July 18, 2022

**RE: Chick-Fil-A @ Coors Pavilion – Additional Parking Lot  
4001 Coors Blvd NW  
Conceptual Grading & Drainage Plan  
Engineer's Stamp Date: 06/28/22  
Hydrology File: G11D069C**

Based upon the information provided in your submittal received 06/30/2022, the Conceptual Grading & Drainage Plan **is not** approved for action by the DRB on Site Plan for Building Permit. The following comments need to be addressed for approval of the above referenced project:

**C-2.0**

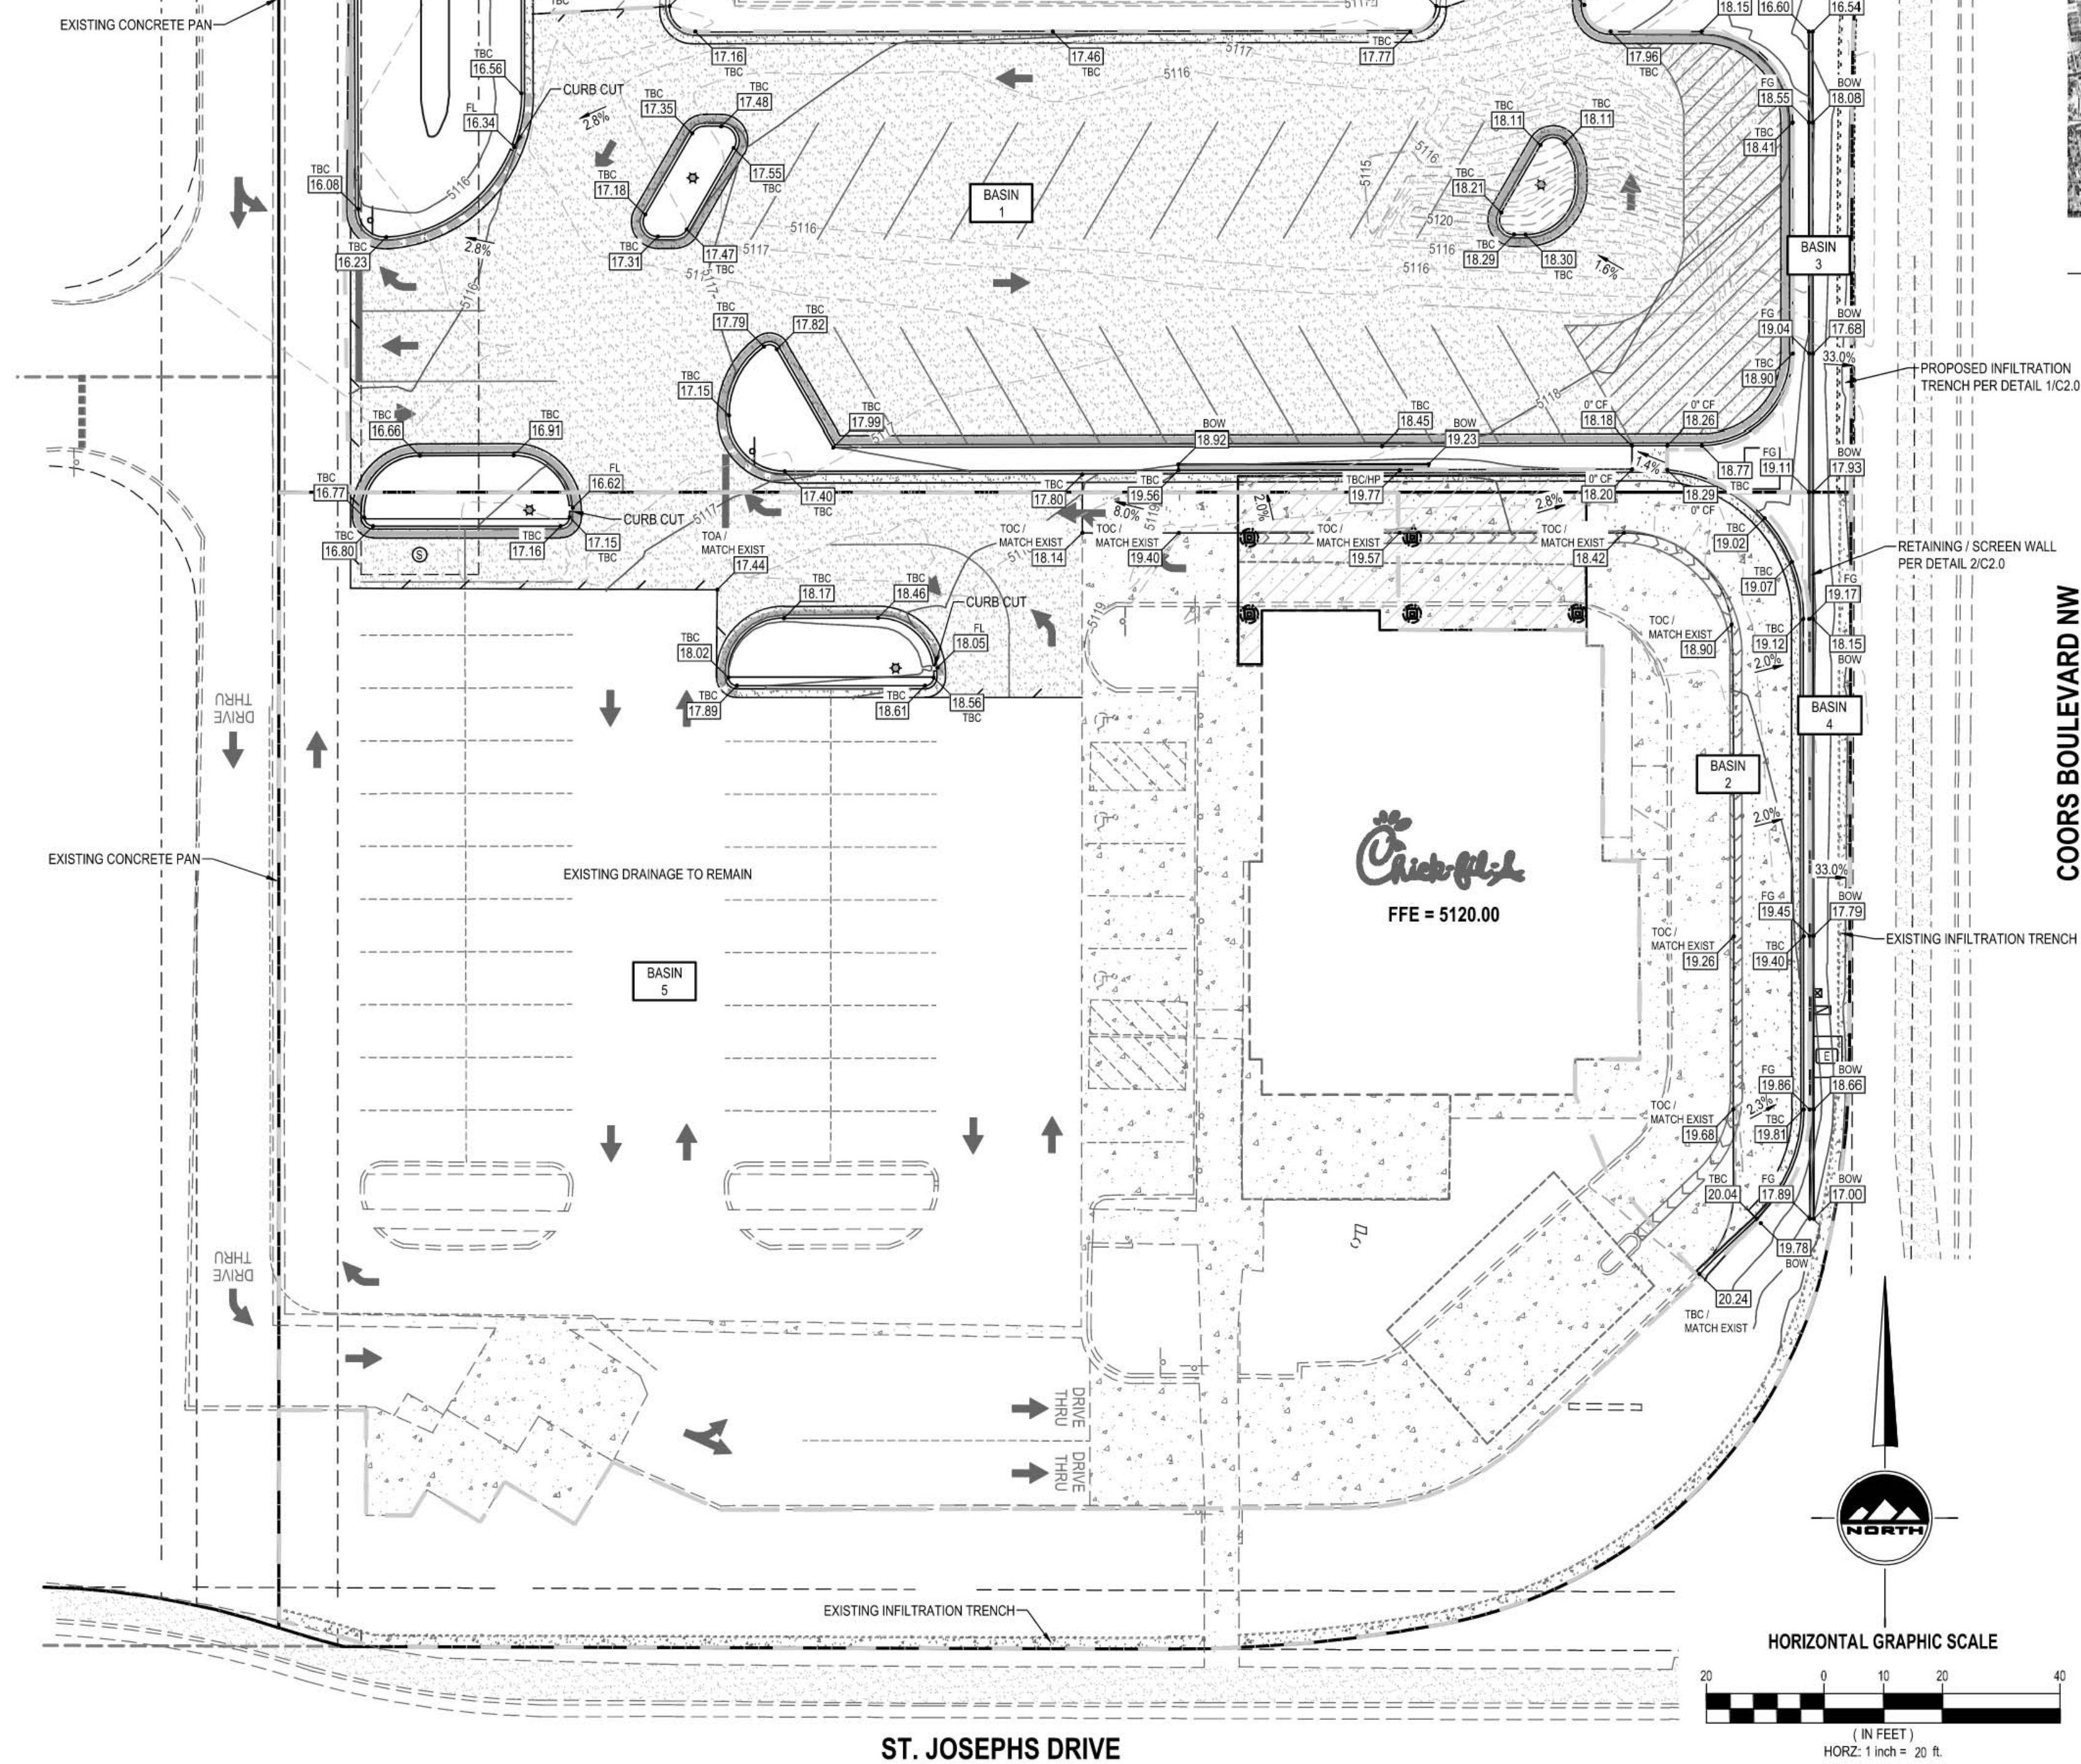
1. Under Existing Conditions, please refer to the Amended Master Drainage Plan dated 12/2020 by Respec. Lot 5 (which the project is on) has a designed allowable discharge of 2.90 cfs which was designed to go directly north into Lot 4 but could be discharge into the private access / drainage easement which ultimately discharges into the Coors Pavilion detention pond.

2. Please use the procedure for 40 acre and smaller basins as outlined in Development Process Manual (DPM) Article 6-2(a). Please provide both the existing conditions and proposed conditions for the 100 year-6 hour storm event. Please show the calculations per the DPM and not just the end result.

3. Please follow the DPM Article 6-12 Stormwater Quality and Low-Impact Development for the sizing calculations. To calculate the required SWQV, multiply the impervious area draining to the BMP by 0.42 inches for new development sites.

4. Please provide the SWQV calculations for each basin draining to each pond. The stormwater quality ponds need to be sized for the areas draining to them.

5. Please label the size of each curb cut and please provide the weir calculations, per DPM Article 6-16(A), for the curb cuts. A coefficient of 2.7 is typically used for the weir equation  $Q = CLH^{2/3}$ .

6. Not sure where the drainage from Basin 2 (the new drive lane) is going. This drainage cannot go directly into Coors Blvd. This is not allowed. I do not see how this is directed towards the interior private access / drainage easement.
